TRI-LAKES MONUMENT FIRE PROTECTION DISTRICT

February 13, 2018

Subject: FD Road access for Settlers View Subdivision

TITLE: **SETTLERS VIEW SUBDIVISION Preliminary Plan**  
DATE: **11-09-16**  
SCALE: **1"=100'**  
DRAWN BY: **JMN**  
SHEET: **1** OF **1**

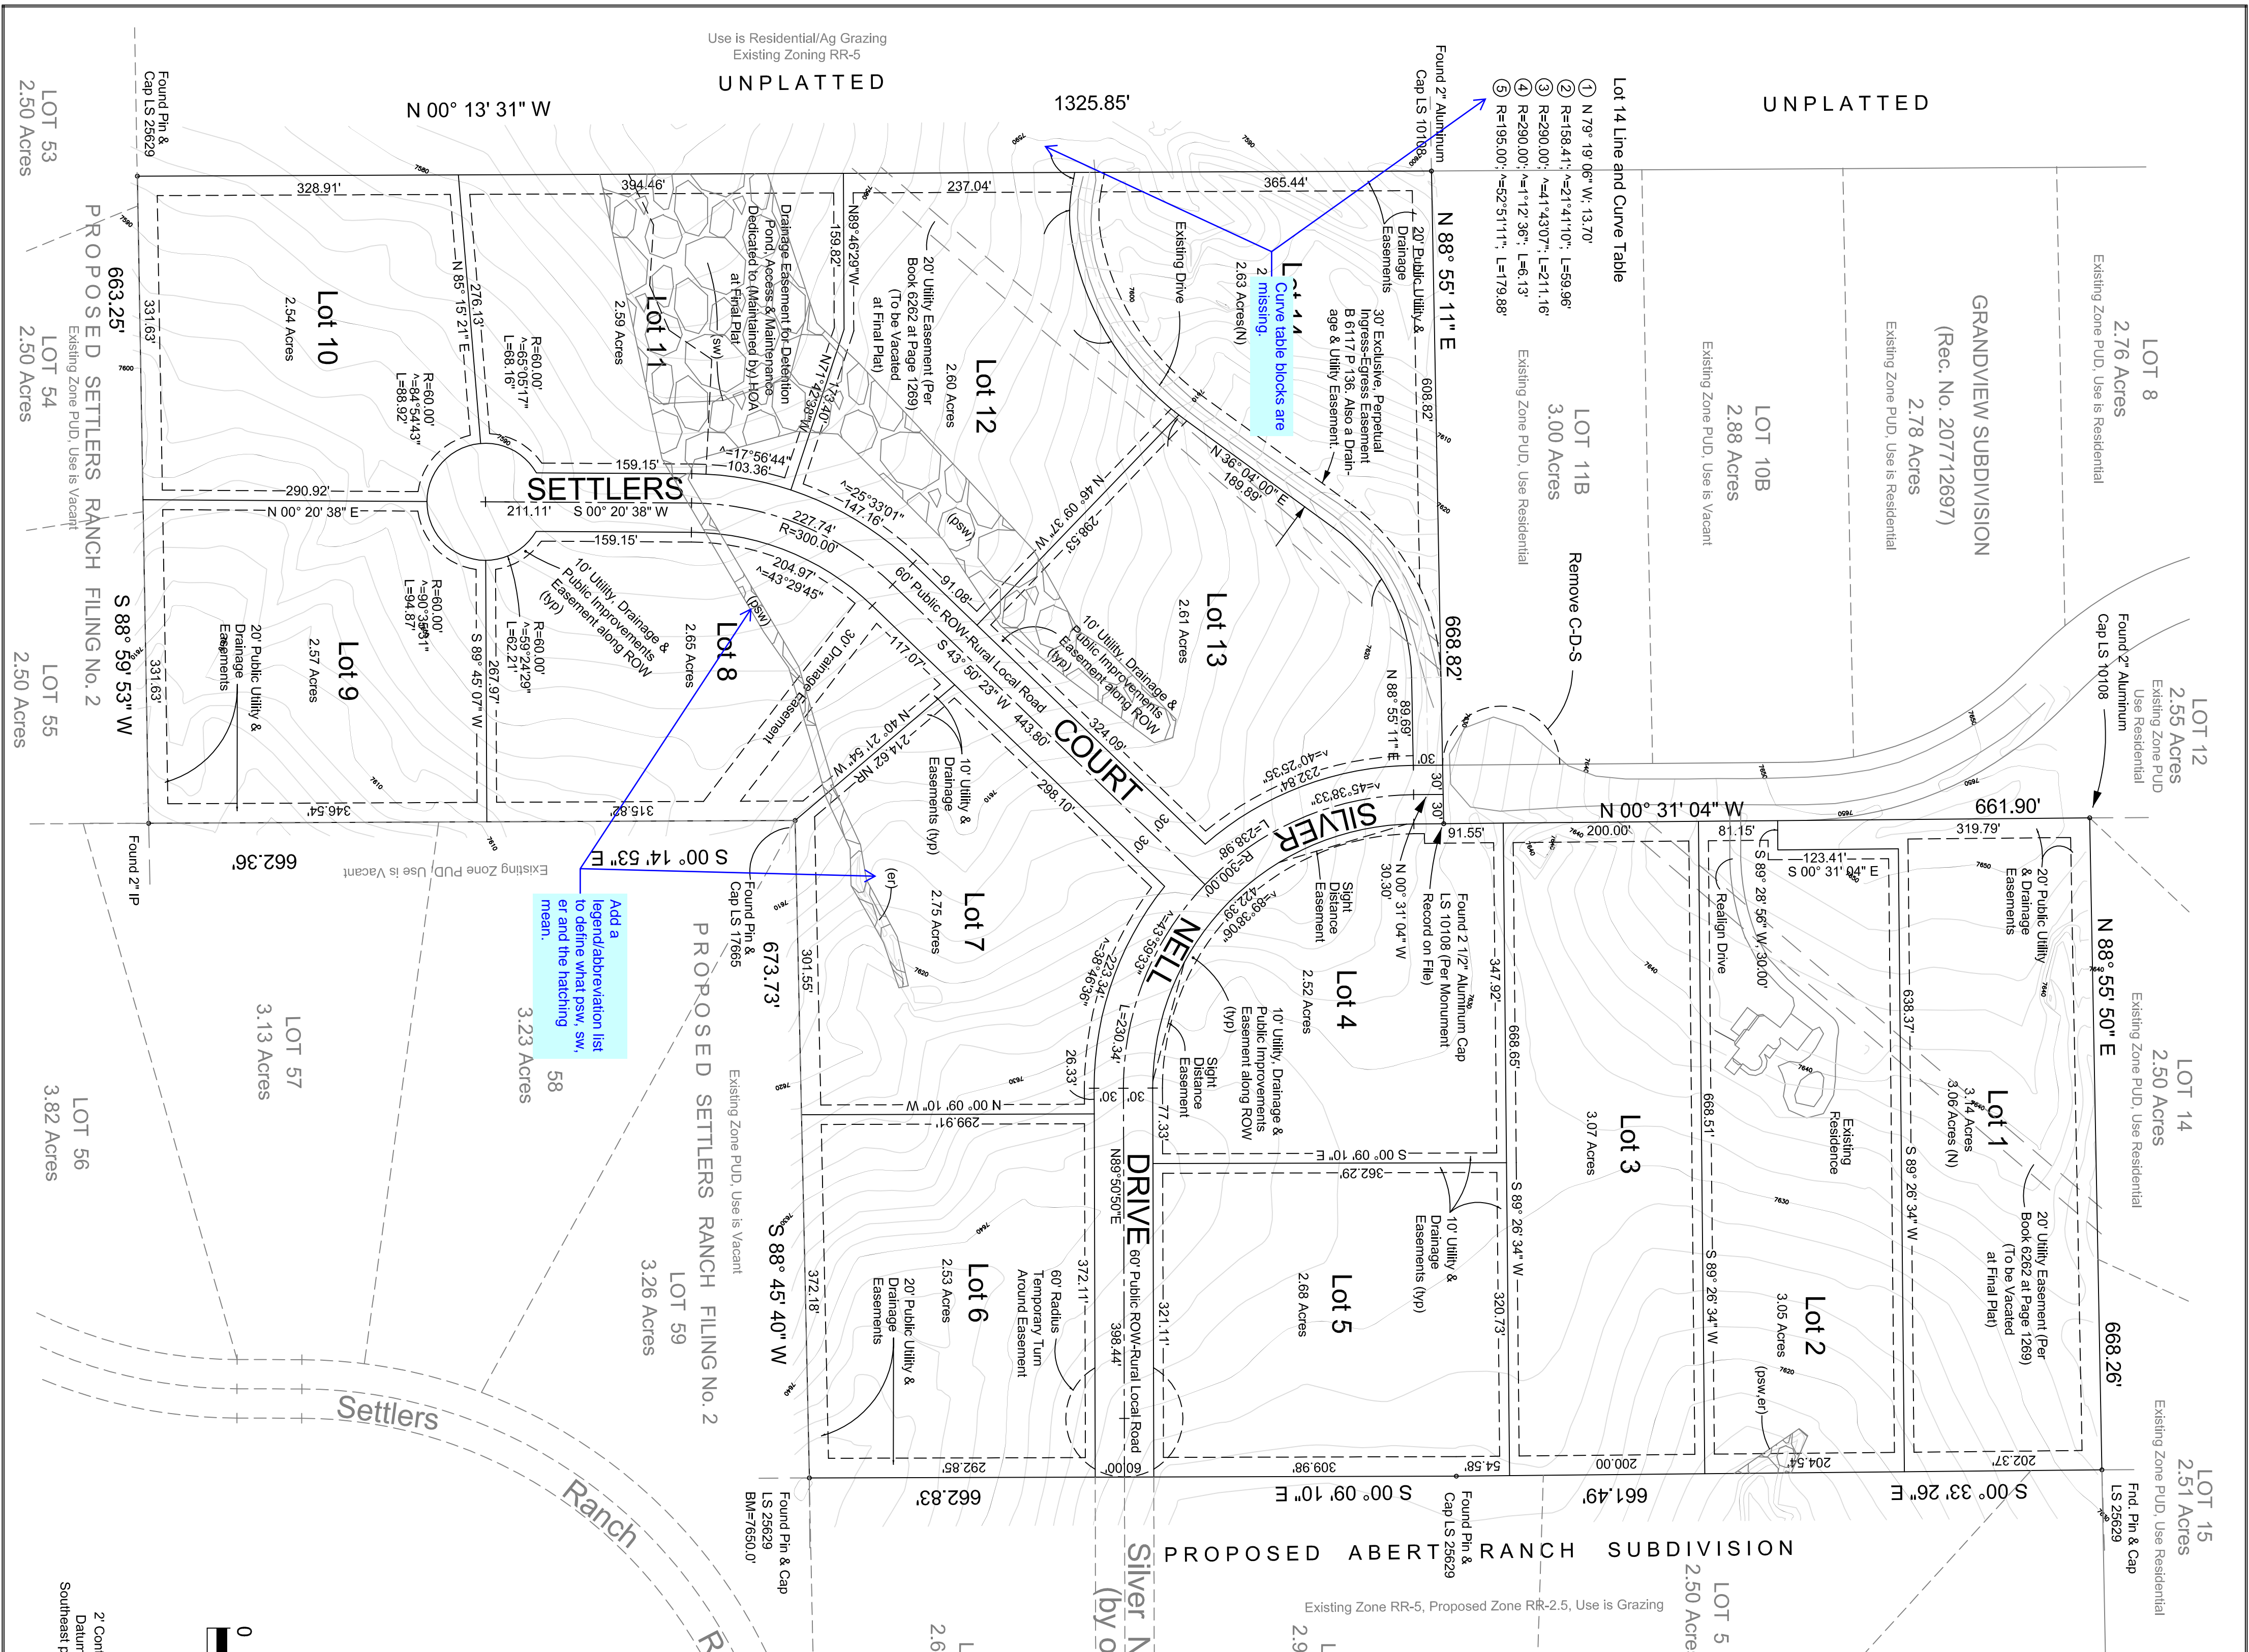
1. We acknowledge that the current road in the Grandview Subdivision (17 Lots) is Silver Neil Drive (4,288 feet long) will be extended an additional 898 feet to accommodate an additional 14 additional residential lots. All roadways will conform to the adopted 2009 IFC.
2. Silver Neil drive will be required to have a cul-de-sac because it is considered a Fire Department Access road and therefore should conform with Appendix D (Included Below) as a minimum.
